# East West Rail Phase 2

### Stage 2 Road safety audit response report

### Offline Highways Passing Places – Package 2 – Oxfordshire (A3 Marsh Gibbon – Compound Access)

**Document Number: 133735\_RW-EWR-XX-XX-RP-CH-000049**

Drawing Title
PASSING PLACE A3_P_10 EXISTING UTILITIES AND SITE CLEARANCE

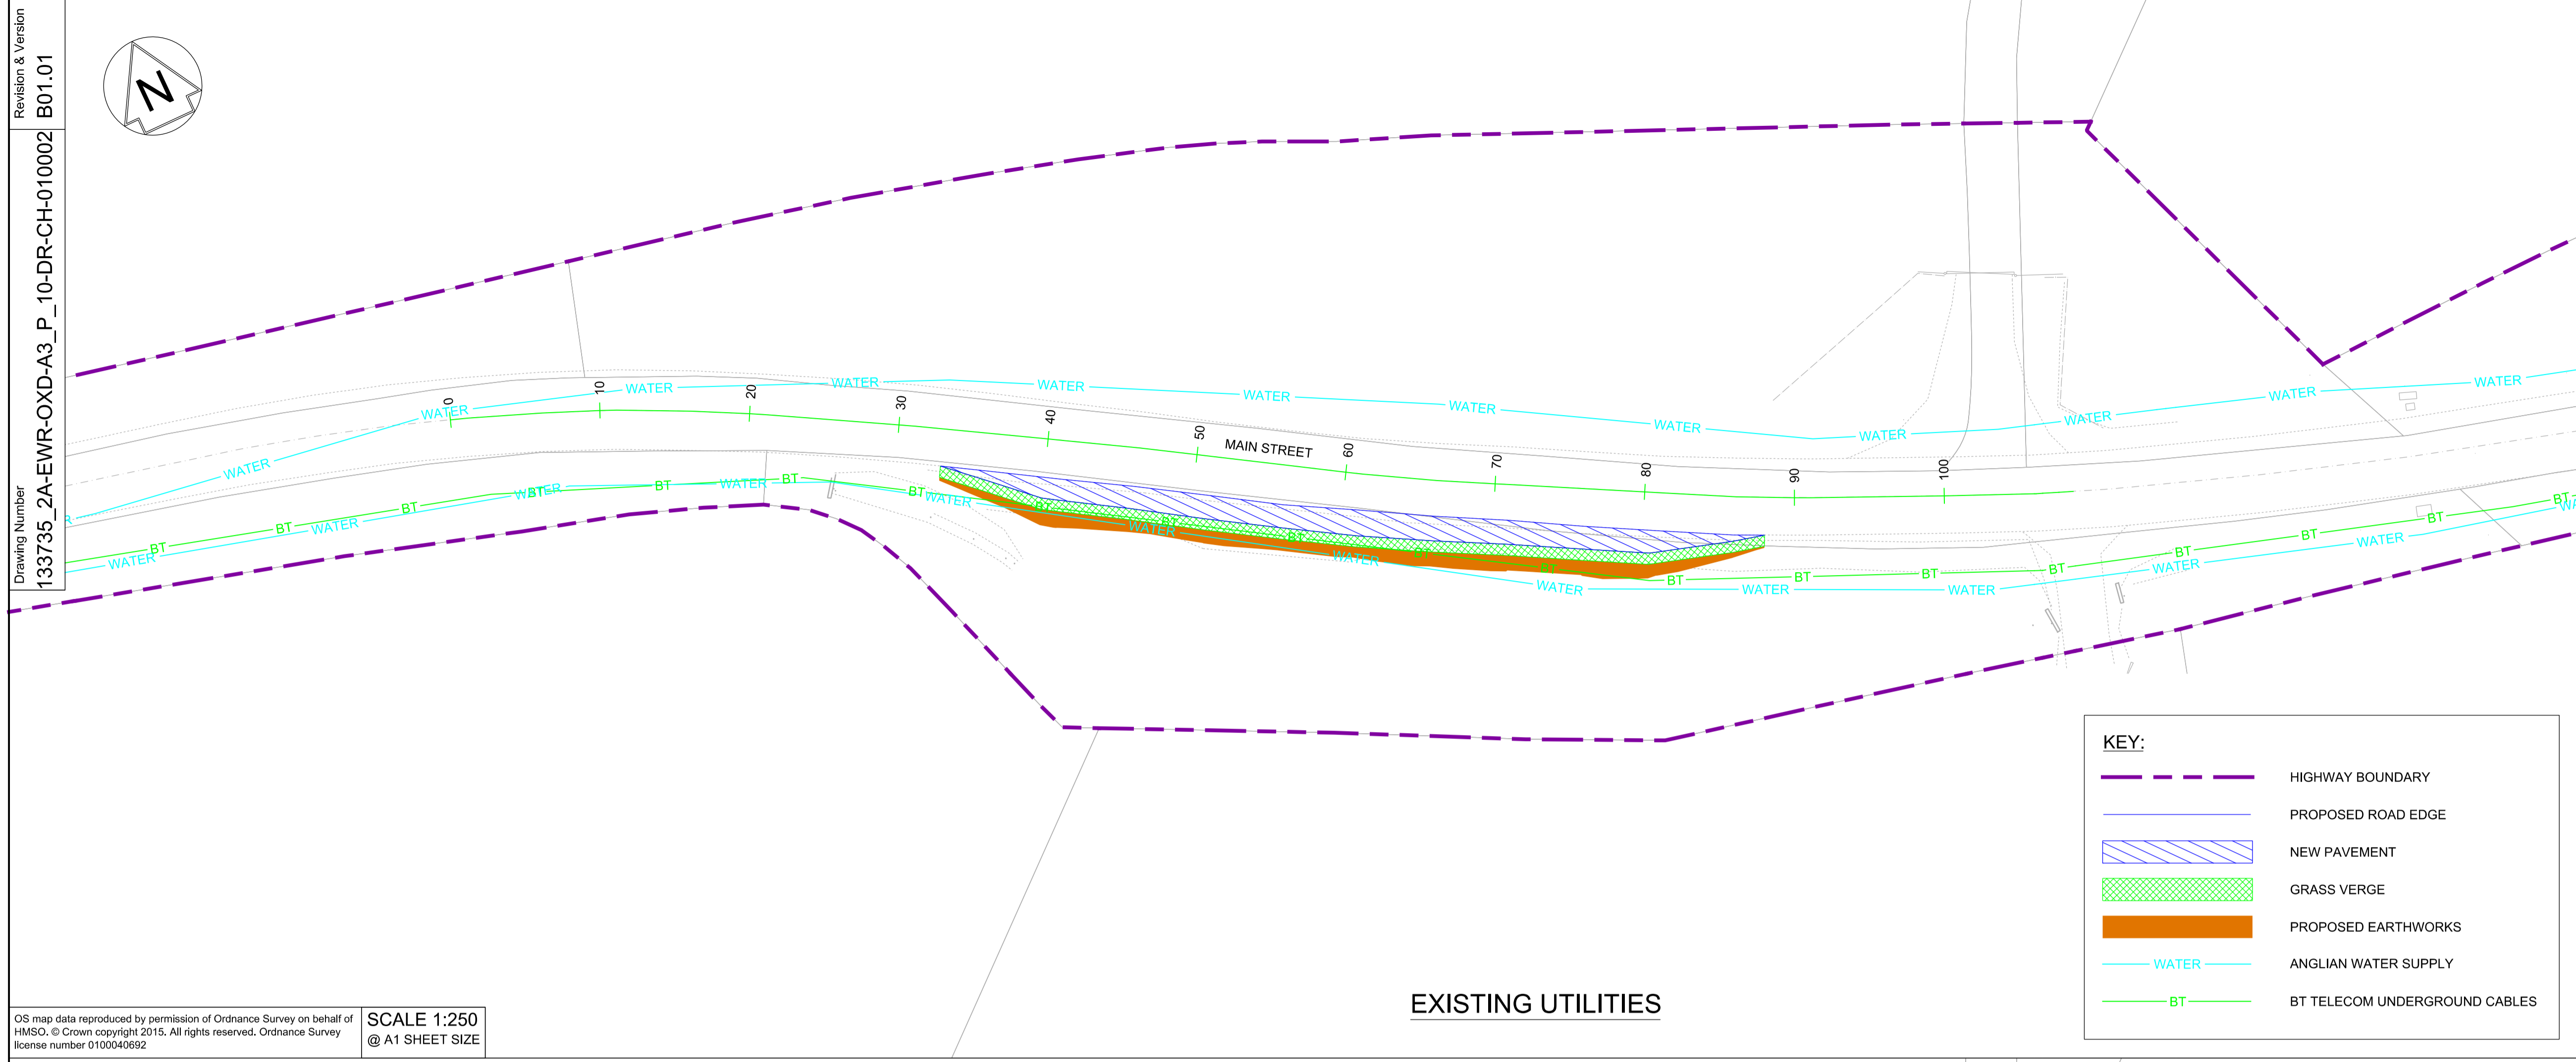
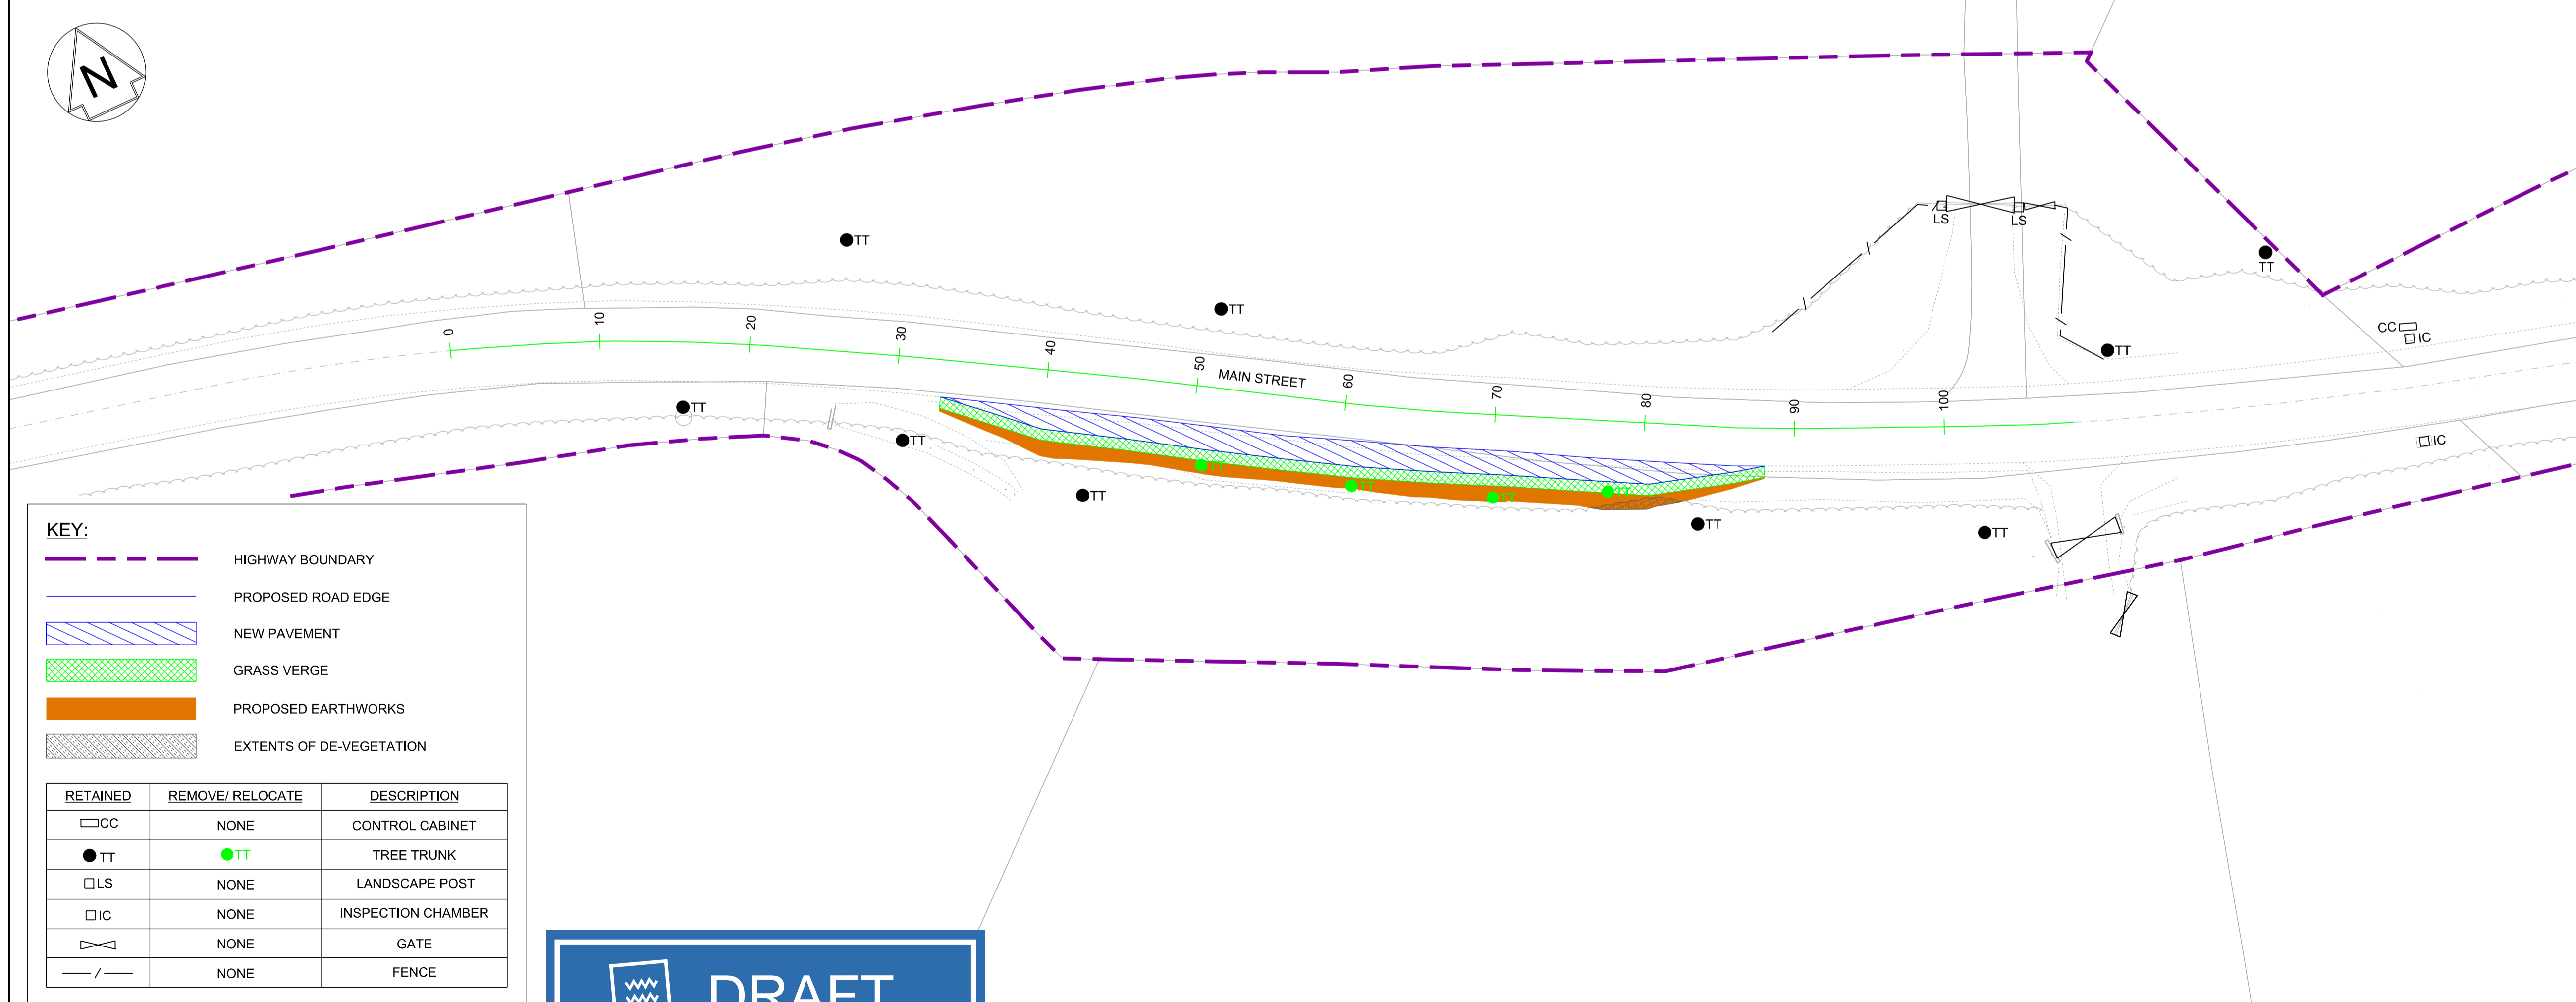
**Summary:** Proximity of passing place to farm traffic access increases risk of collision. There are accesses used by farm traffic along the Unnamed Road (towards Mill Road). As a farm vehicle enters or exits these accesses from Unnamed Road (towards Mill Road), there is a likelihood that a construction vehicle may collide with it as they may not anticipate the turning farm vehicle, particularly when they are preparing to enter the passing place. This issue is exacerbated by the presence of vegetation around these accesses which reduces the visibility between farm traffic and construction drivers using the Unnamed Road (towards Mill Road).

Provide traffic signing to warn of construction passing places and farm traffic accesses. Trim back vegetation around the accesses to maximise intervisibility.

RSA Ref	Location	RSA Problem	RSA Recommendation	Design Team Response	Network Rail Response	Agreed RSA action
2.4	<p>Passing Places A2-P-1, A3-P-2, A3-P-3, A3-P-5, A3-P-7 and A3-P-10. Unnamed Road (towards Mill Road) and Unnamed Road.</p>	<p><b>Proximity of passing place to farm traffic access increases risk of collision</b>                      There are accesses used by farm traffic along the Unnamed Road (towards Mill Road). As a farm vehicle enters or exits these accesses from Unnamed Road (towards Mill Road), there is a likelihood that a construction vehicle may collide with it as they may not anticipate the turning farm vehicle, particularly when they are preparing to enter the passing place. This issue is exacerbated by the presence of vegetation around these accesses which reduces the visibility between farm traffic and construction drivers using the Unnamed Road (towards Mill Road).</p>	<p>Provide traffic signing to warn of construction passing places and farm traffic accesses. Trim back vegetation around the accesses to maximise intervisibility</p>	<p><b>Accept the RSA problem and recommendation made by the RSA team.</b>                      The design includes a signage strategy which provides signs to notify drivers that the road has passing places. The site clearance drawings include vegetation clearance to achieve required visibility and signage strategy drawings likewise include this provision.</p>	Accepted	Proceed as Design Team Response
